***MODIFICATION REQUEST:  
Residential Development Stage 1 Phase 1  
Royal Rehabilitation Centre, Ryde  
MP10\_0189***

***Modifications to Residential Flat Building***

Director-General's  
Environmental Assessment Report  
Section 75W of the  
*Environmental Planning and Assessment Act 1979*

September 2012

NORTH-WEST ELEVATION

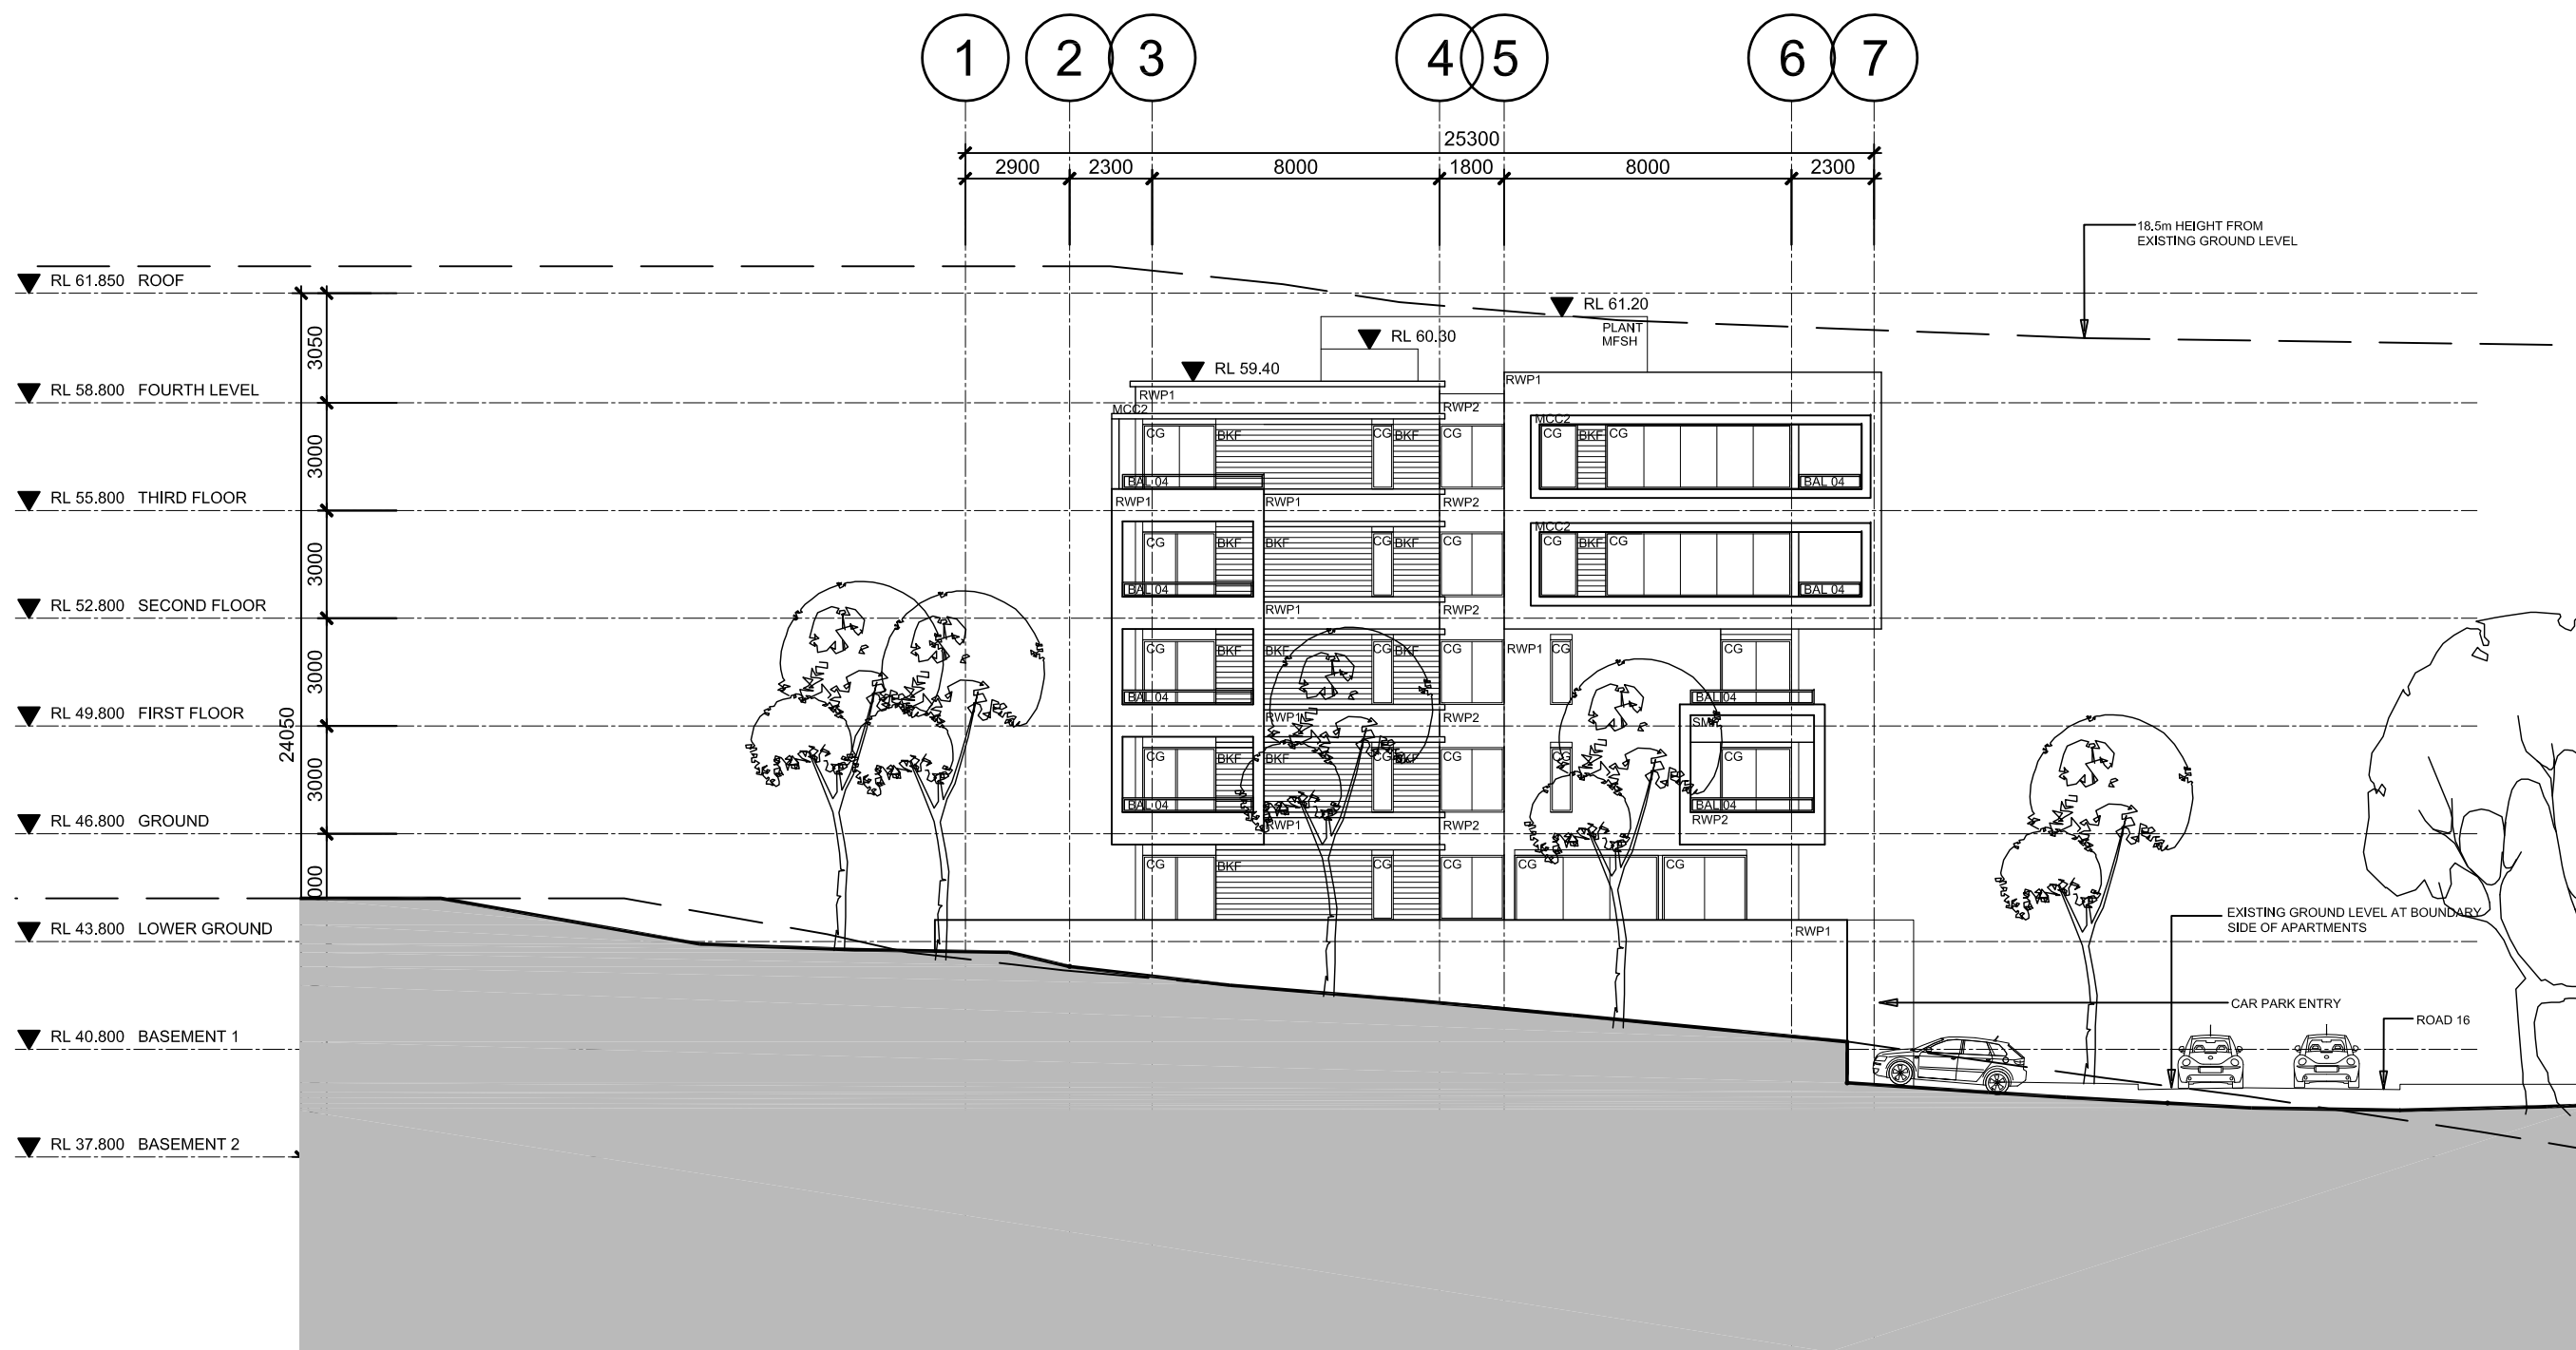
The proposed modification increases the height of the approved residential flat building. The proposal also increases the floor space and therefore the bulk at the upper levels. The resulting visual impact is demonstrated by the photomontages in **Figure 2** and **Figure 3**.

While the highest point of the modified building would only be only 0.25 metres higher than that approved, some parts of the building are increased in height by as much as 3 – 6 metres. As a result, the proposal, in particular the roof top plant, no longer fully complies with the 18.5 metre height control under the Ryde Local Environmental Plan (LEP).

Given that the proposed building will be visible from the adjoining Calvary Retirement Village, it is considered that the visual impacts of the building should be no greater than that permitted under the controls. A reduction in the height of the plant enclosures from 2.4 metres to 1.6 metres is required to ensure compliance with the LEP control. The proponent advises that it is possible to screen all plant with a 1.6 metre high enclosure and as such a condition is recommended requiring the plans to be amended so that all plant screening is within the 18.5 metre height limit.

As discussed in Section 5.1, a condition is recommended requiring a reduction in height to comply with the 18.5 metre control.
